KIRKLEES METROPOLITAN COUNCIL INVESTMENT & REGENERATION SERVICE

DELEGATED DECISION TO DETERMINE APPLICATIONS FOR LISTED BUILDING CONSENT

Reference No:	2025/44/92476/W
Site Address:	Queensgate Market, Princess Alexandra Walk, Huddersfield, HD1 2UJ
Description:	Discharge of details reserved by conditions 14 (blinds), 15 (flooring), 17 (market stalls), 19 (partition wall/glazed screen) on previous permission 2024/90270 for Listed Building Consent for demolition, alteration, refurbishment and extension to create library, food hall and public realm (part within a Conservation Area)
Recommending Officer:	Katie Chew

Application: 2025/92476

6 Coat of Arms Display Case - Key Plan
1 : 1000

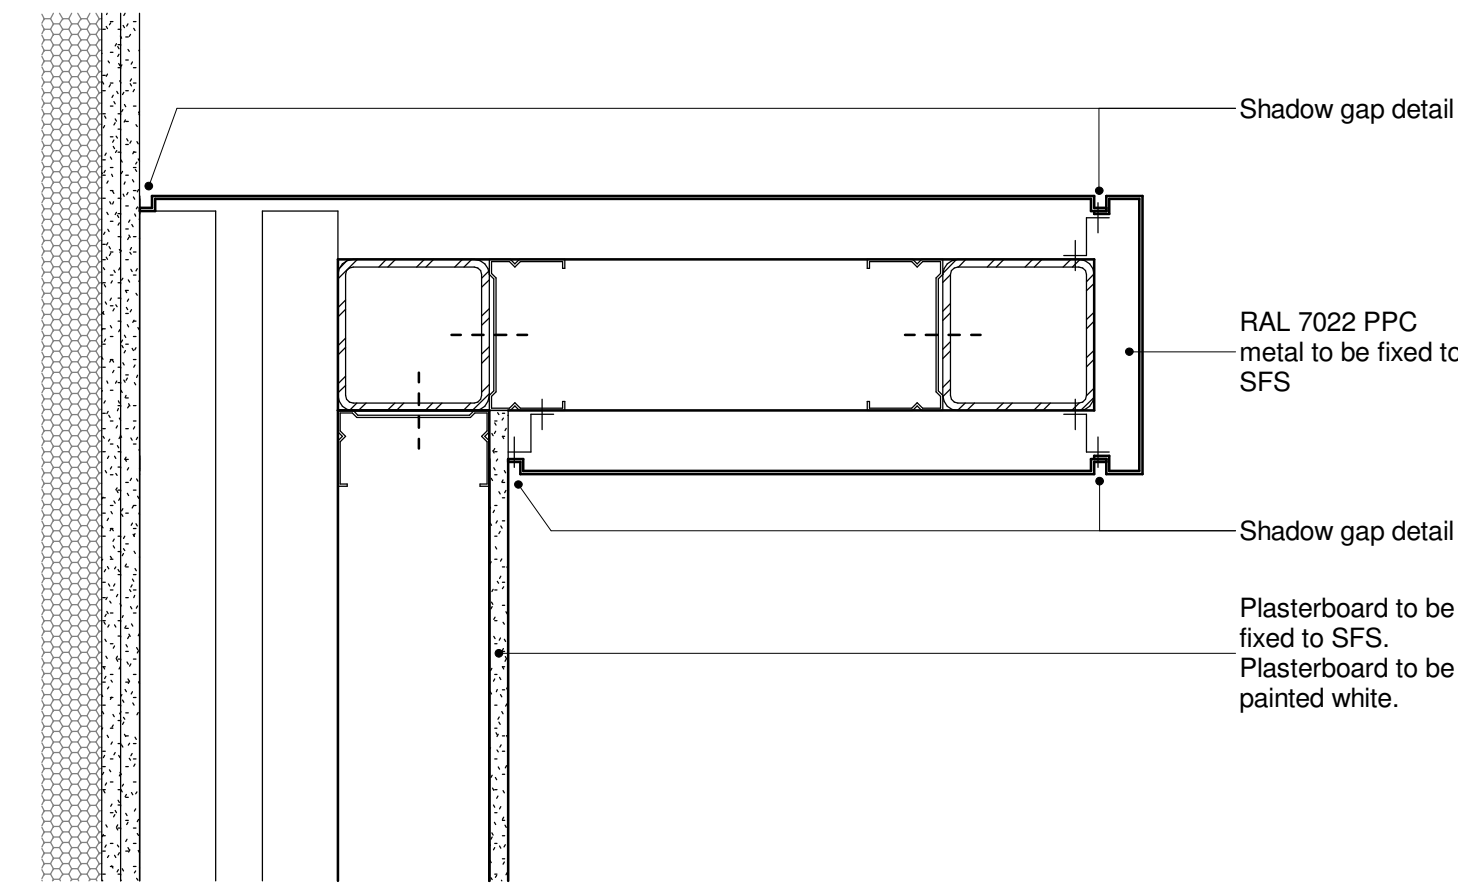
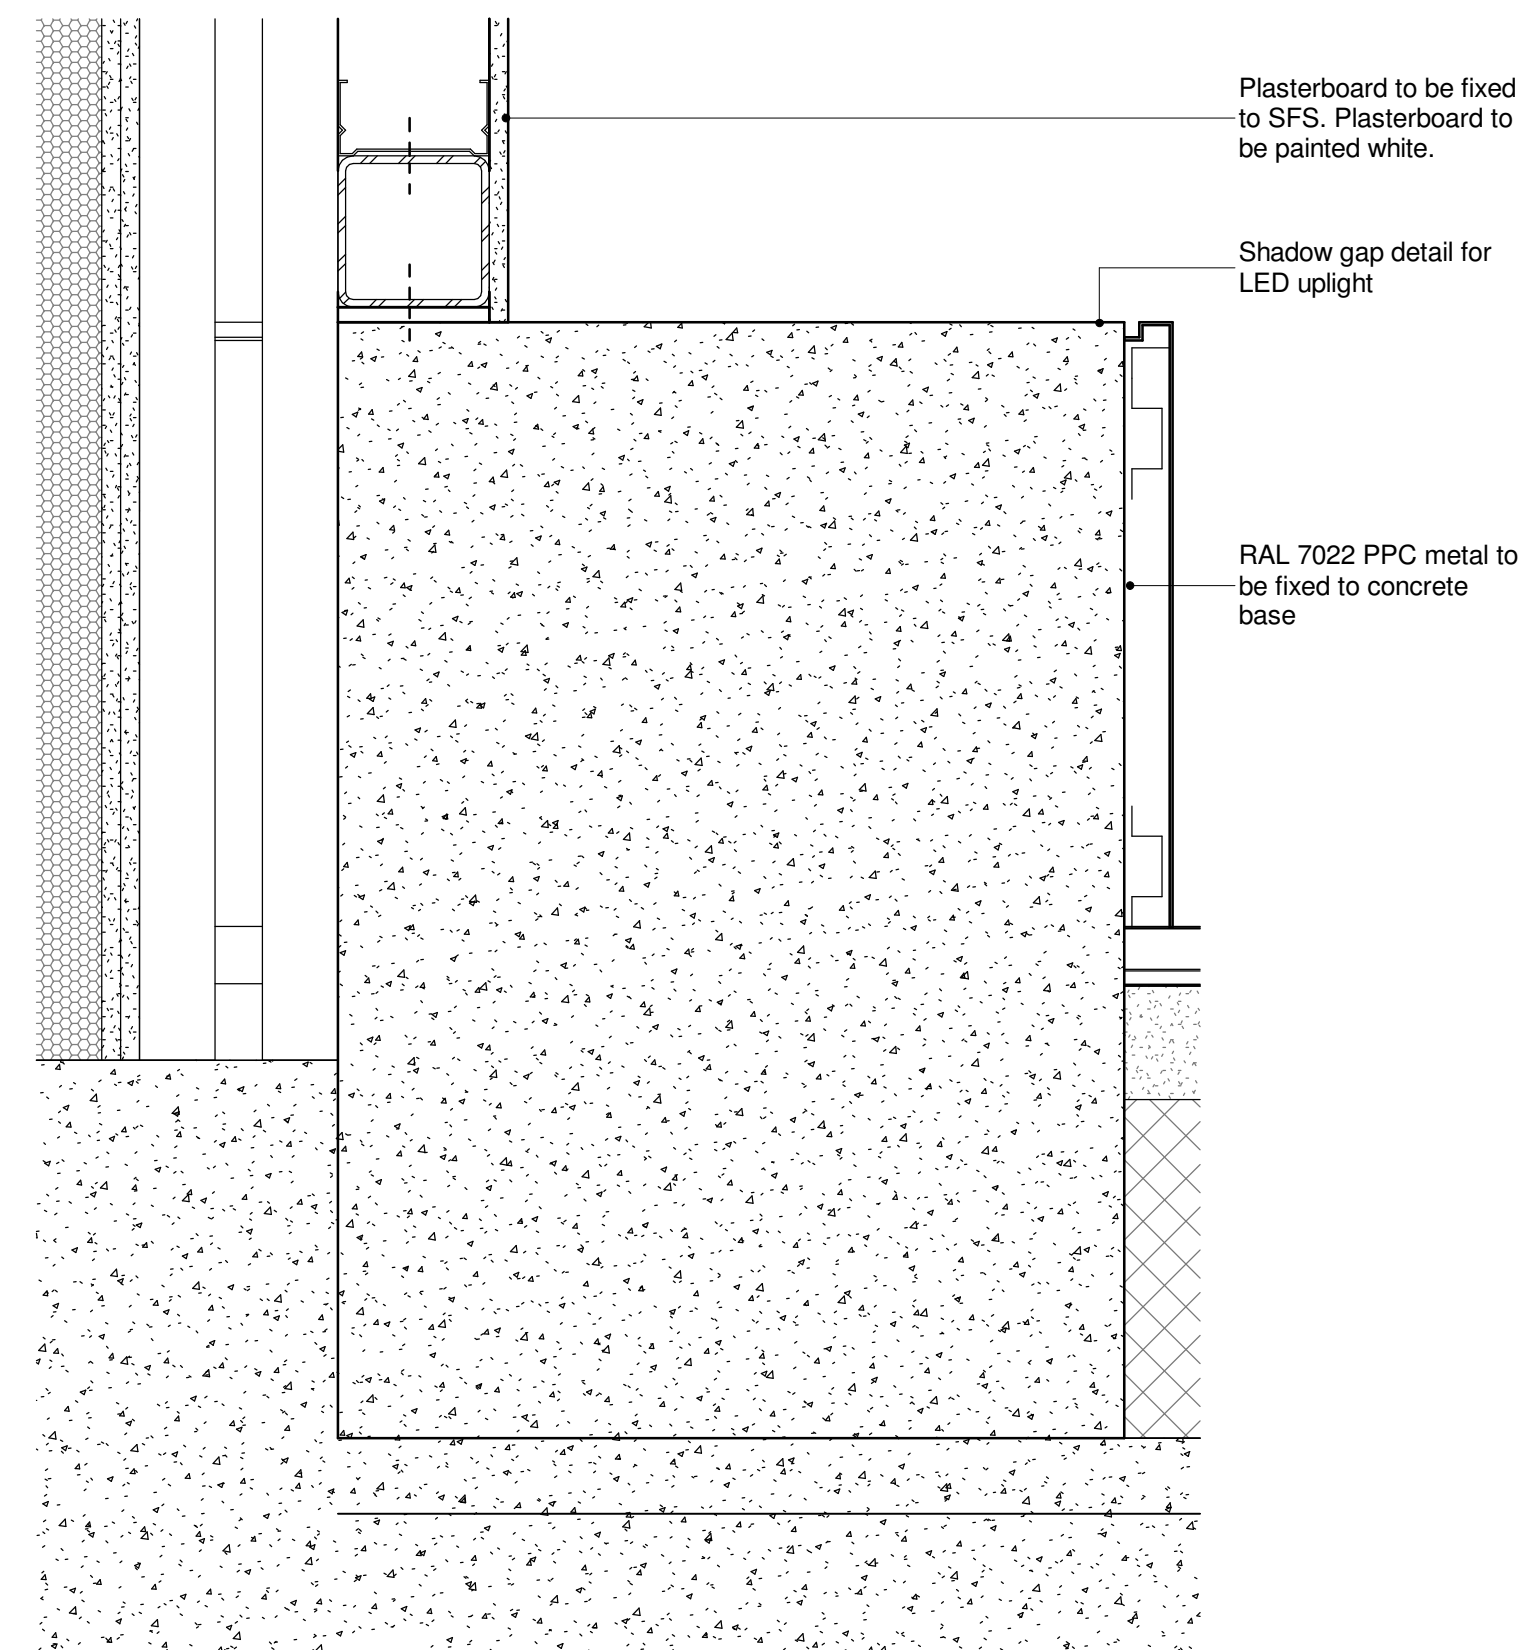
17. The retained market stalls refers to some retained terrazzo upstand panels that will be refixed to the rear entrance as shown on the following drawing. The location and reason for this was explained at a site visit on 25th July 2025. [Conservation & Design Officers] had previously intended that they should be reused in the new food halls, so the proposal is to fix them to the dividing wall at the rear entrance of the food hall.

Officers concur with the conclusions made by KC Conservation & Design and therefore recommend that Condition 17 is approved. However, Condition 17 has the following ongoing requirement, which must be adhered to, to ensure the ongoing compliance of the condition:

1.1 GROUND FLOOR PLAN

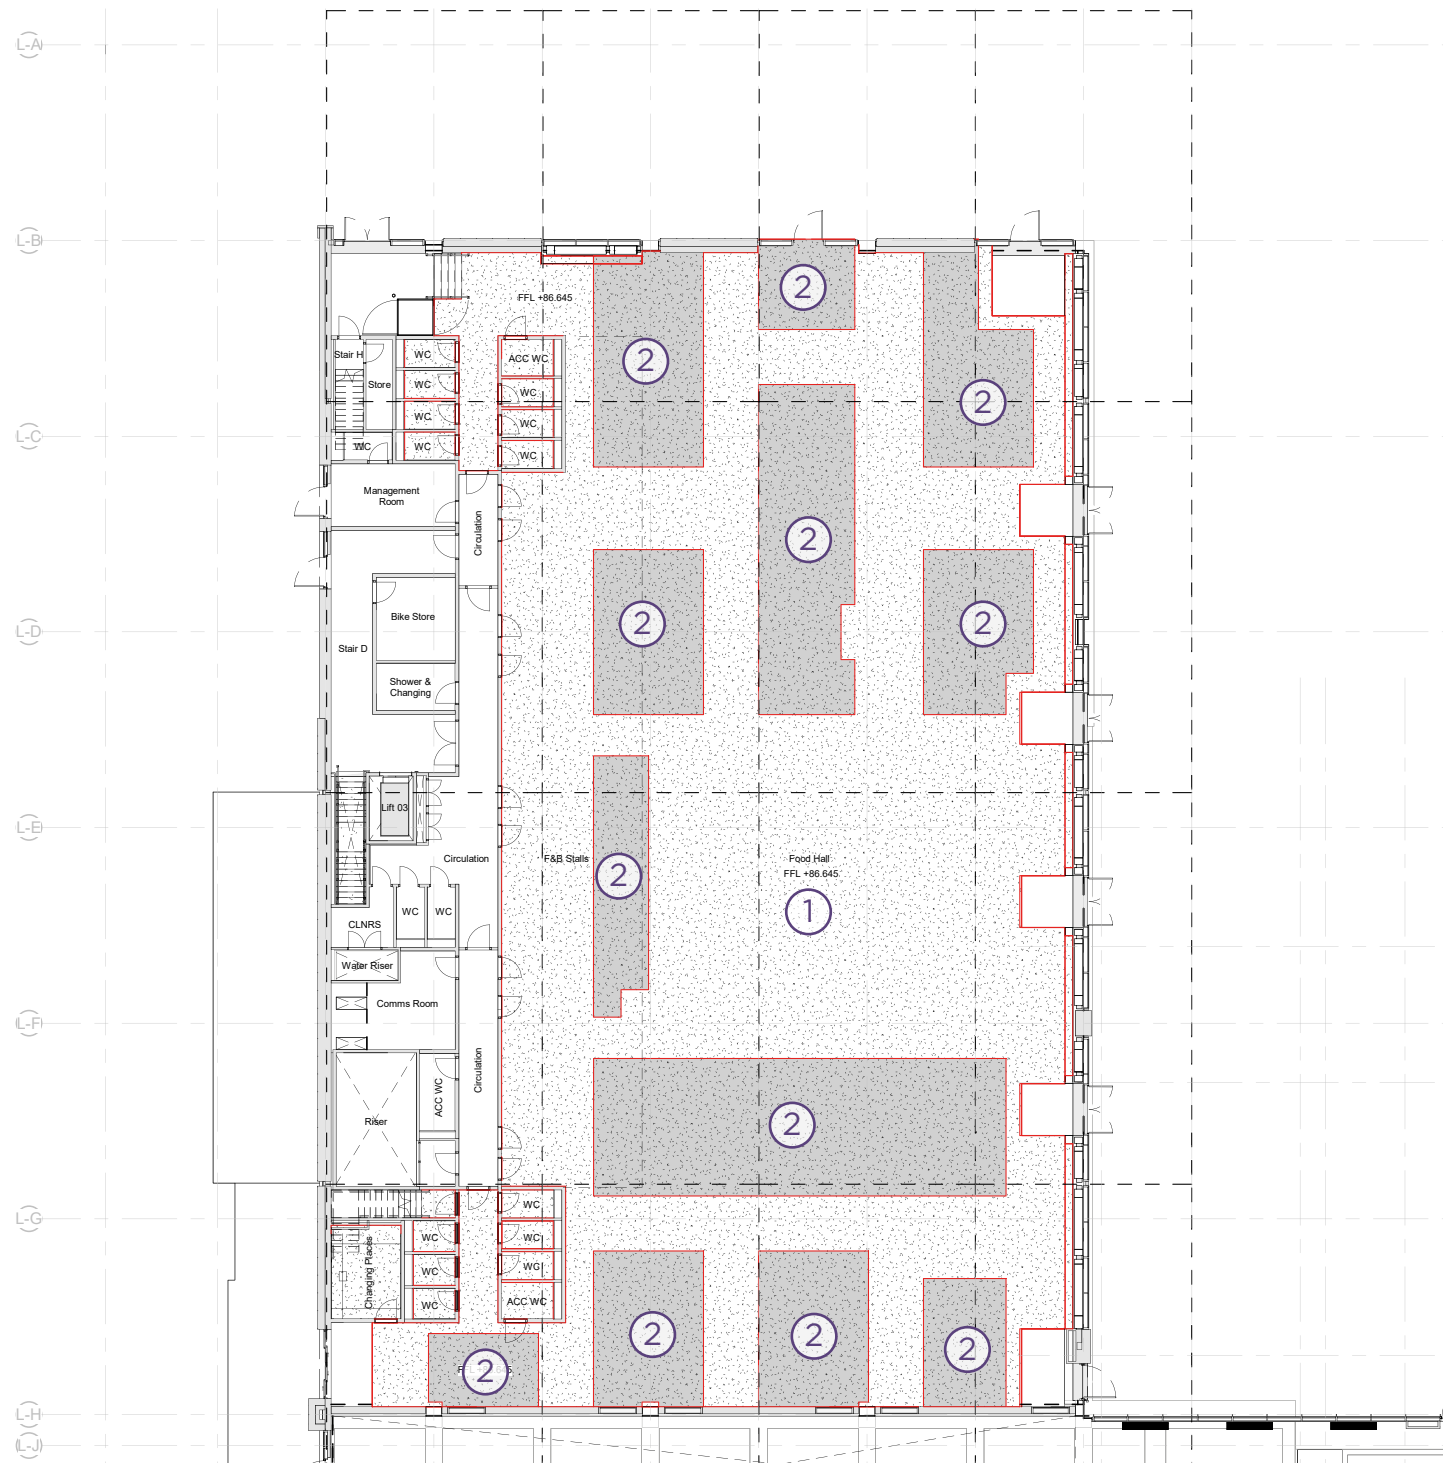
15. The terrazzo samples are light grey and darker grey to match as closely as possible what existed previously. I have seen samples at a meeting on 25th July 2025 and these are acceptable.

Officers concur with the conclusions made by KC Conservation & Design and therefore recommend that Condition 15 is approved. However, Condition 15 has the following ongoing requirement, which must be adhered to, to ensure the ongoing compliance of the condition:

**2 Foodhall / Library / FR Screen Detail**  
1 : 10  
Referenced by 1 / 203002

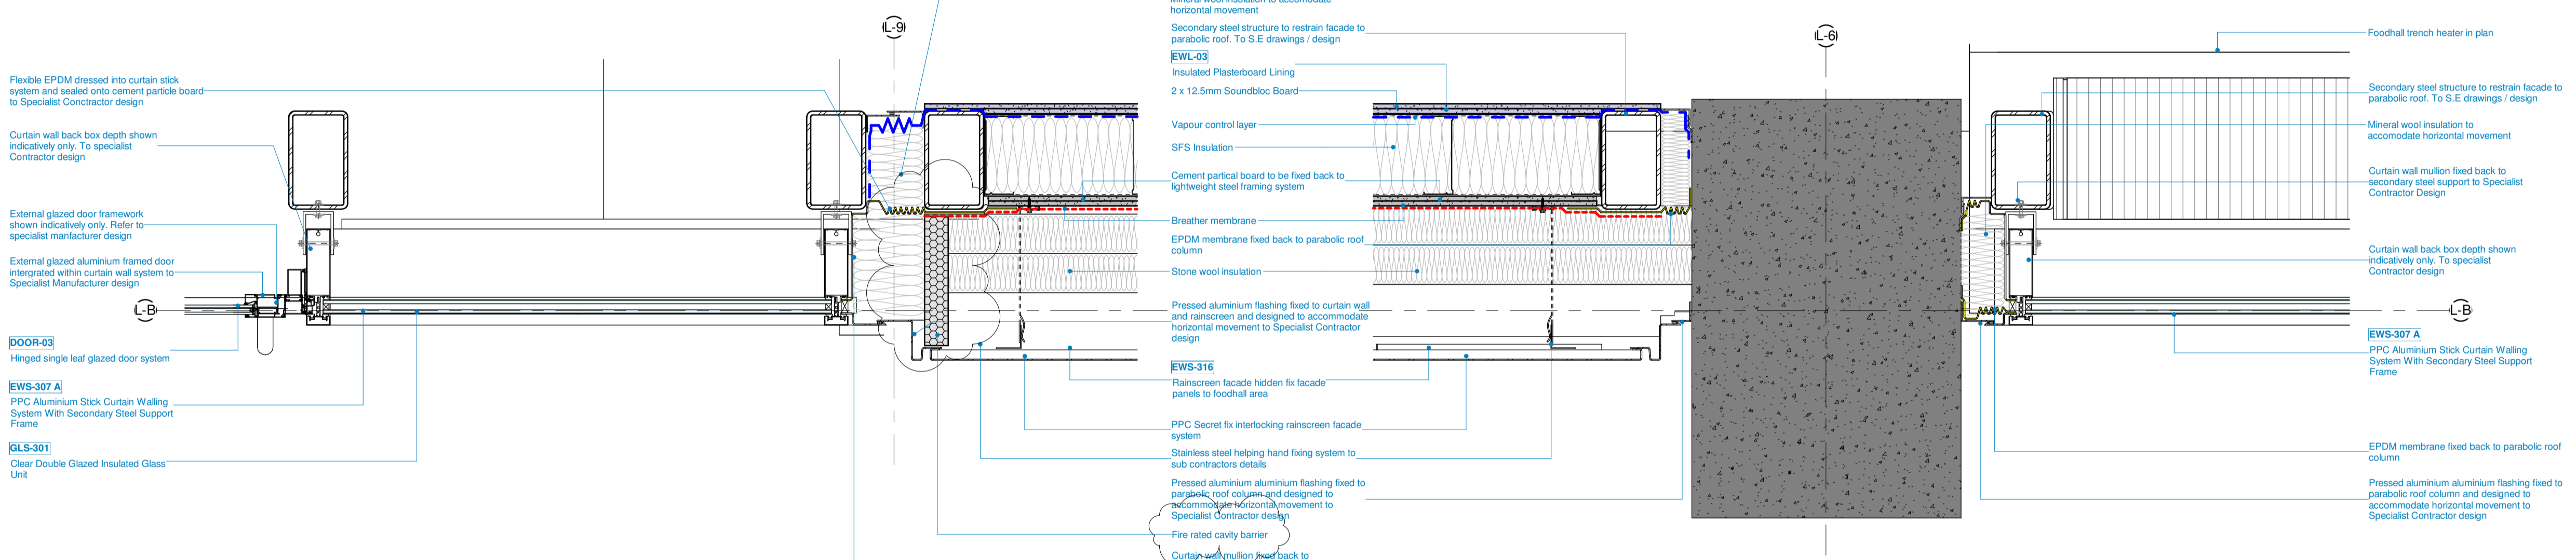
19. Proposed partition wall and glazing between the library and food hall, including detailing and fixings at the junction of the columns and roof structure, material samples, finishes and colour details have been shown in the plans submitted in support of this discharge of condition application.

The details appear to follow the methods proposed for the whole development and appear to be acceptable.

Officers concur with the conclusions made by KC Conservation & Design and therefore recommend that Condition 19 is approved. However, Condition 19 has the following ongoing requirement, which must be adhered to, to ensure the ongoing compliance of the condition:
